Pagham Beach (Holdings) Ltd

30th September 2013

Application ref: P/74/13 - 2 Lagoon Road, Pagham

Extension to rear dormer, new conservatory, new rear wall and detached garage

Land Registry Index map plan

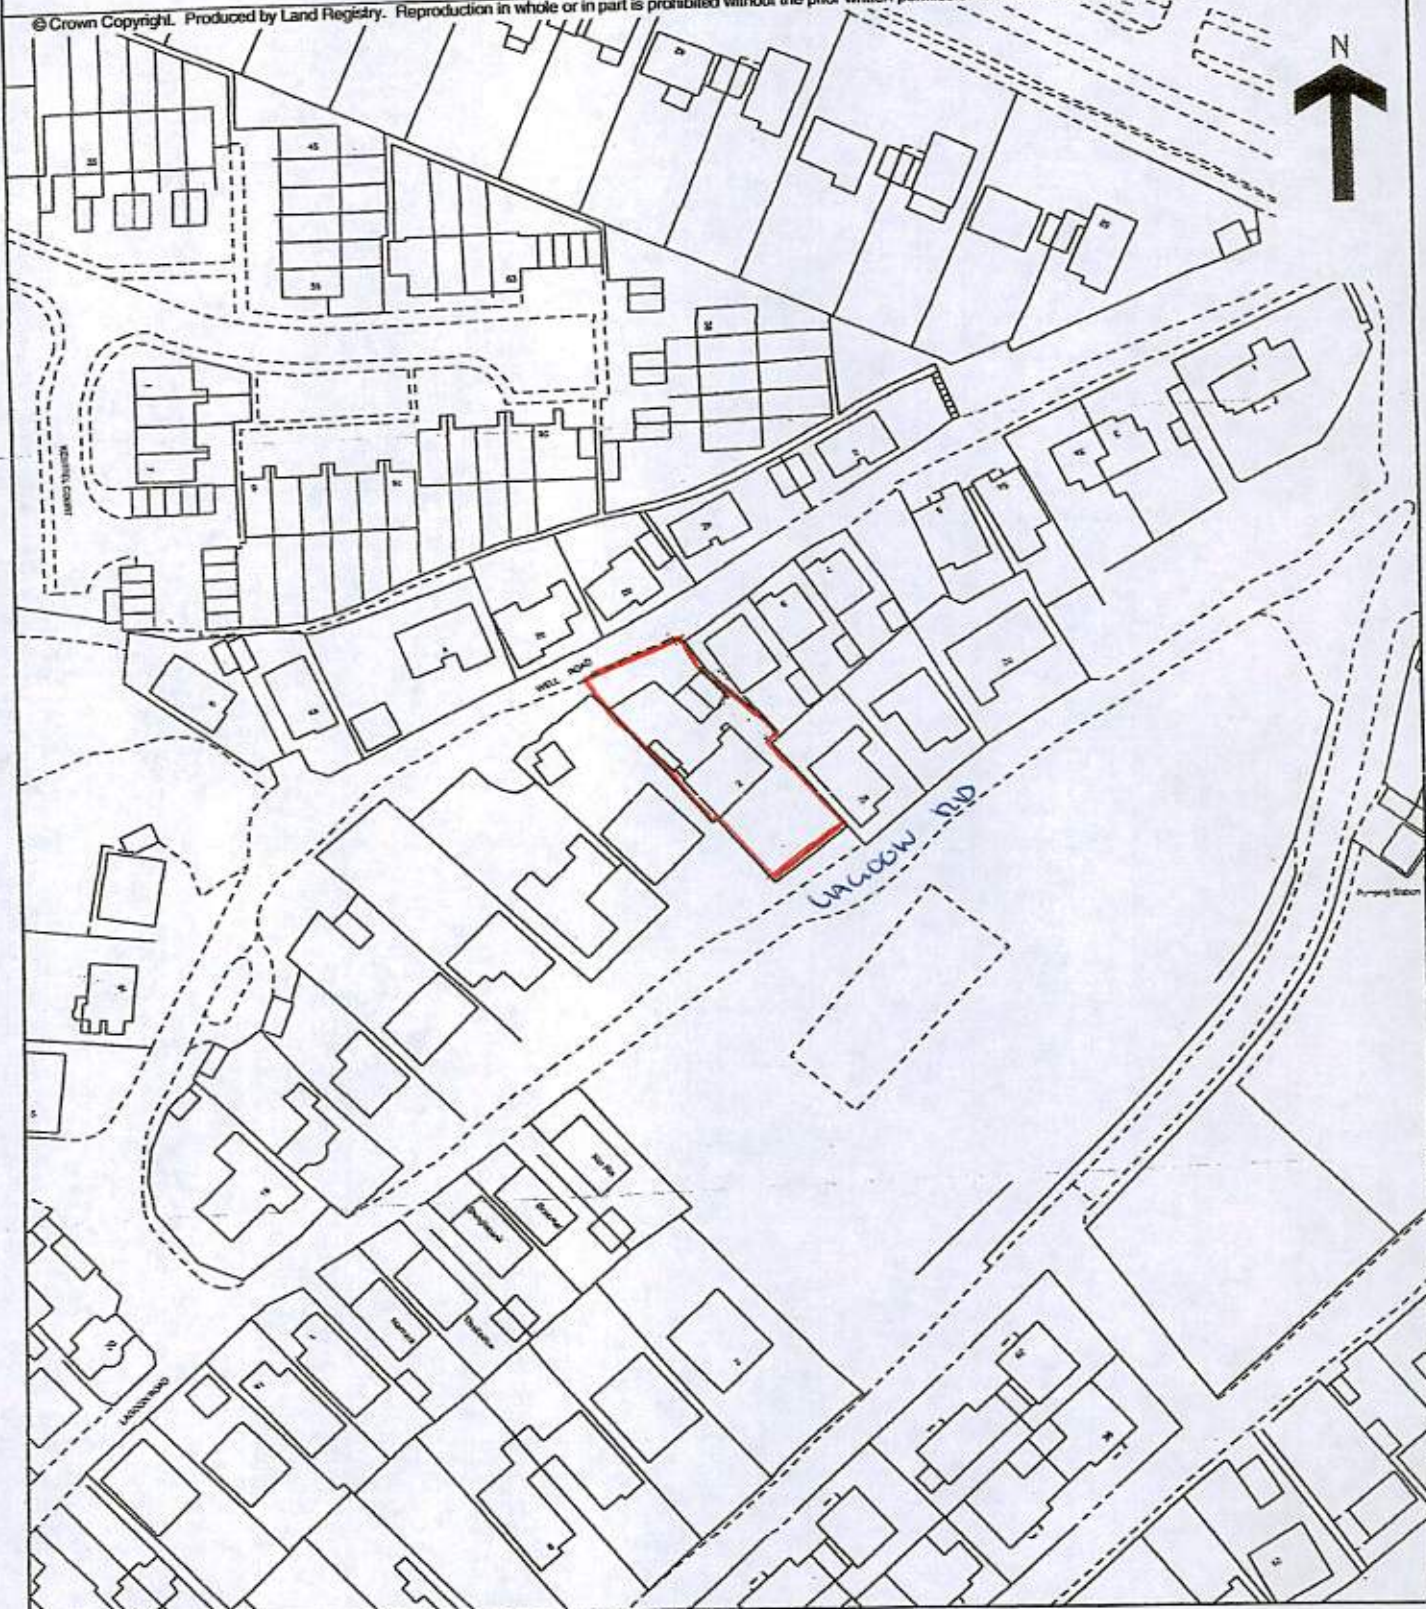
I refer to the above Application, which I have viewed on the District Council's website, and as owner of land adjoining the Application site, wish to object to these proposals in the strongest possible terms. One of the block plans provided with the Application based on a Land Registry plan timed at 24th August 2011, has outlined no.9 Well Road in the same colouring as the Application site, although faint, and this should be clarified.

The new application ref: P/74/13 outlines land in red that is not in the applicant's ownership and needless to say the Company has not received Notice of the application from Mr. Grace. The application must therefore be considered invalid.

PROPOSED
DORMER EXTENSION
CONSERVATORY
REAR WALL & GARAGE

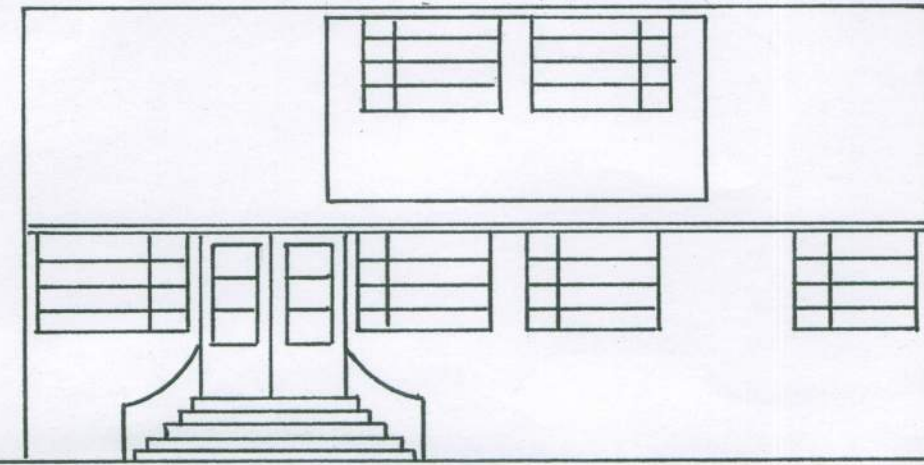
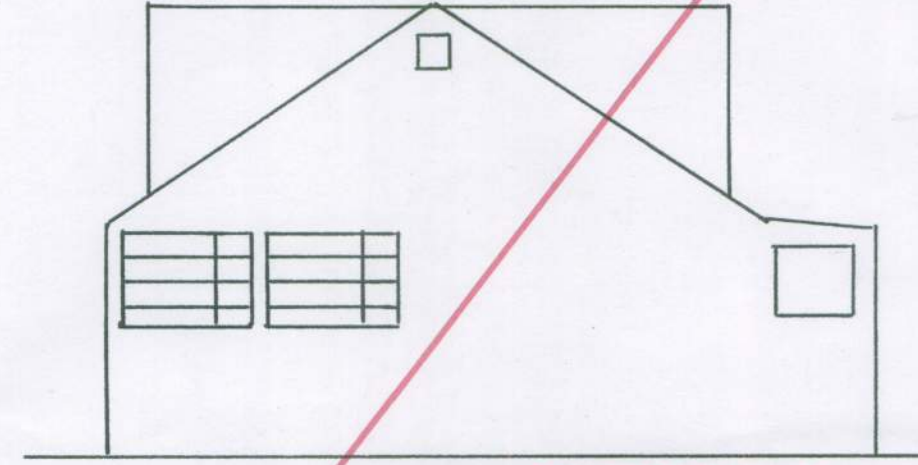
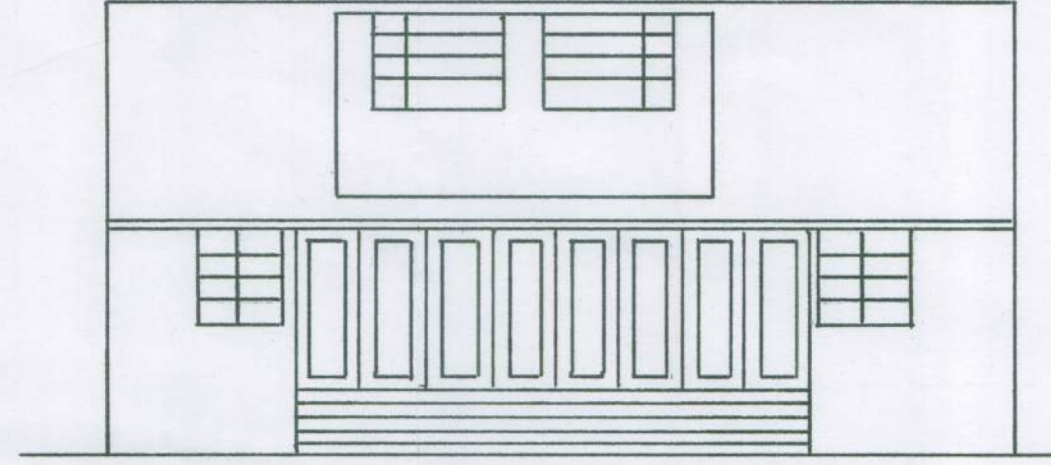
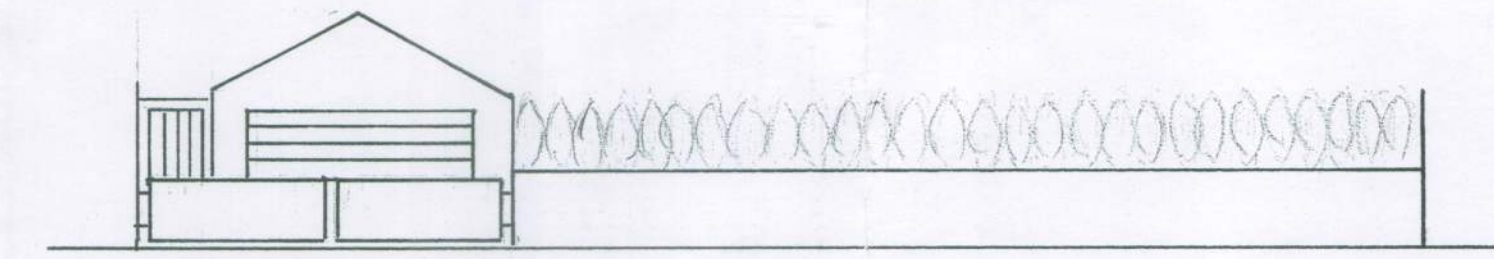
The property is situated on the Pagham Beach estate which is limited by Planning Policy to single-storey development. The existing first floor that has been erected to this property is contrary to this Planning policy, and no further first floor extensions should be permitted. The rear dormer proposed will cause considerable overlooking to bungalows in Well Road and is un-neighbourly. For the foregoing reason therefore this element of the Application should be Refused, or the applicant invited to withdraw this proposal.

The District Council considered an Application to retain a fence that has been erected at the rear of this property under ADC Planning Ref: P/91/12 and this was Refused on 29th January 2013. The applicant referred this Refusal to Appeal, and a decision from the Planning Inspectorate is awaited. Any decision on this element of the Application is therefore premature, and could conflict with an earlier decision by the Planning Authority.

The position of the fence/hoarding that has been Refused, and the new wall, which is now proposed, are both situated on land outside the applicant's ownership or control and are in fact on land in the Company's ownership. The Company has received no Notification of this Application proposal from the applicant and therefore the Application must be considered invalid. The Company previously objected to this proposal and I enclose a copy of the Company's letter of Objection of 24th December 2012 to Application Ref: P/91/12. The Company has similarly objected to this element of this present Application, by e-mail to the Case Officer, and I also enclose a hard copy of my e-mail of 13th September 2013, together with the attachments referred to.

ELEVATIONS REVISED 3/9/13

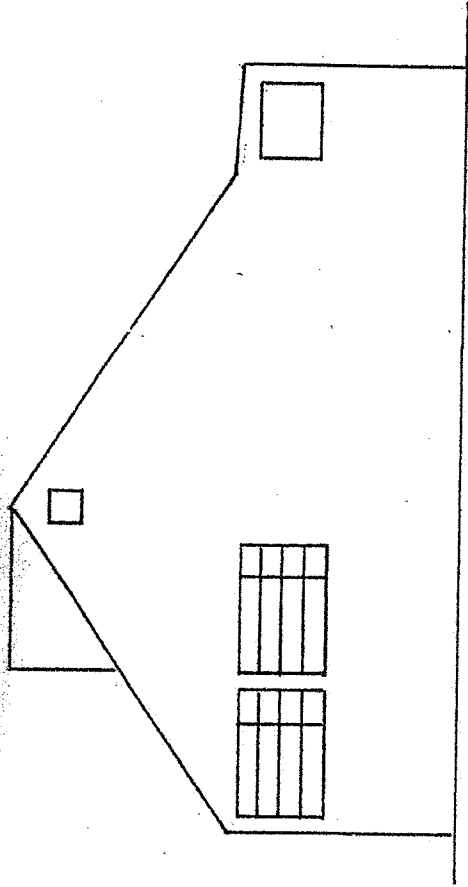
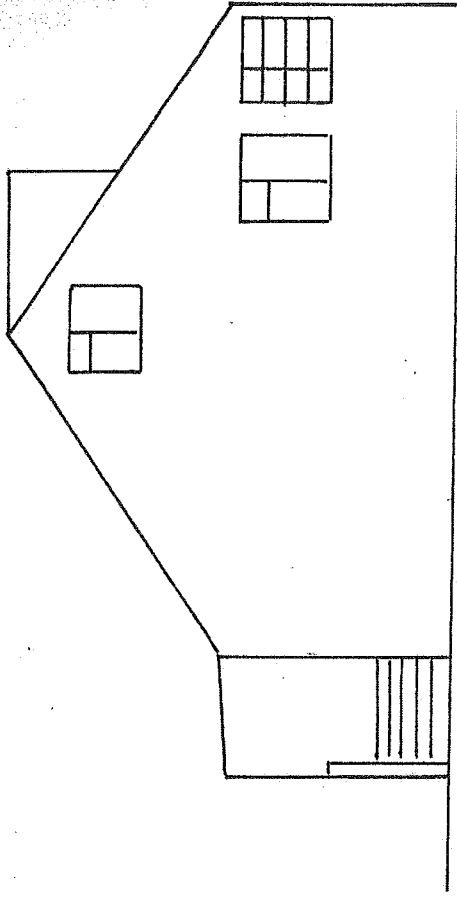
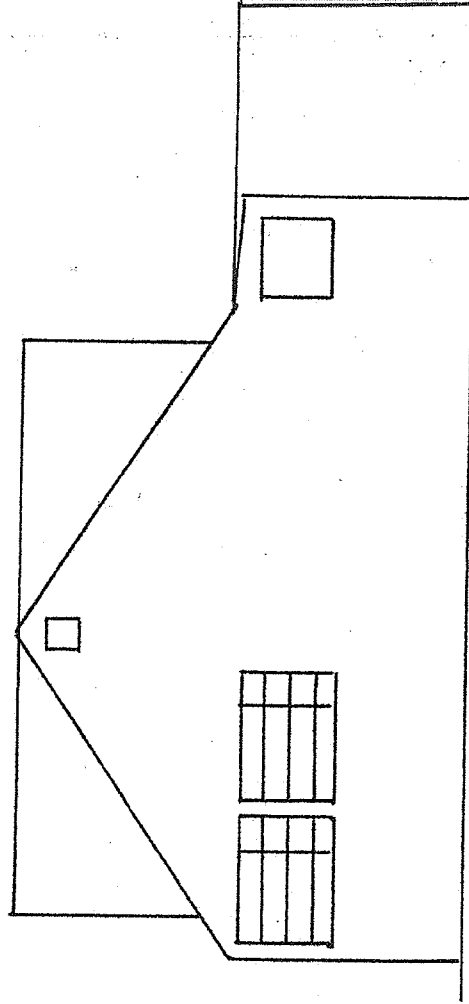
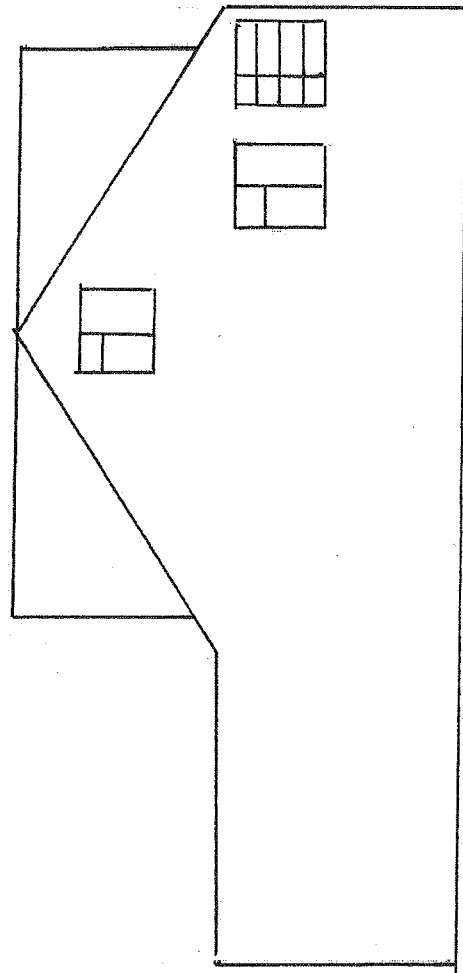
The details submitted by the applicant in relation to this element of the proposal are conflicting and misleading. The Plans submitted imply a single garage extension to an existing single garage, whereas elevation Drawings submitted imply the erection of a new double garage. The Application proposal does not define the vehicular access to this garage, presumably from Well Road, and does not define the position of gates, which again may be on land that is outside the ownership and control of the applicant.
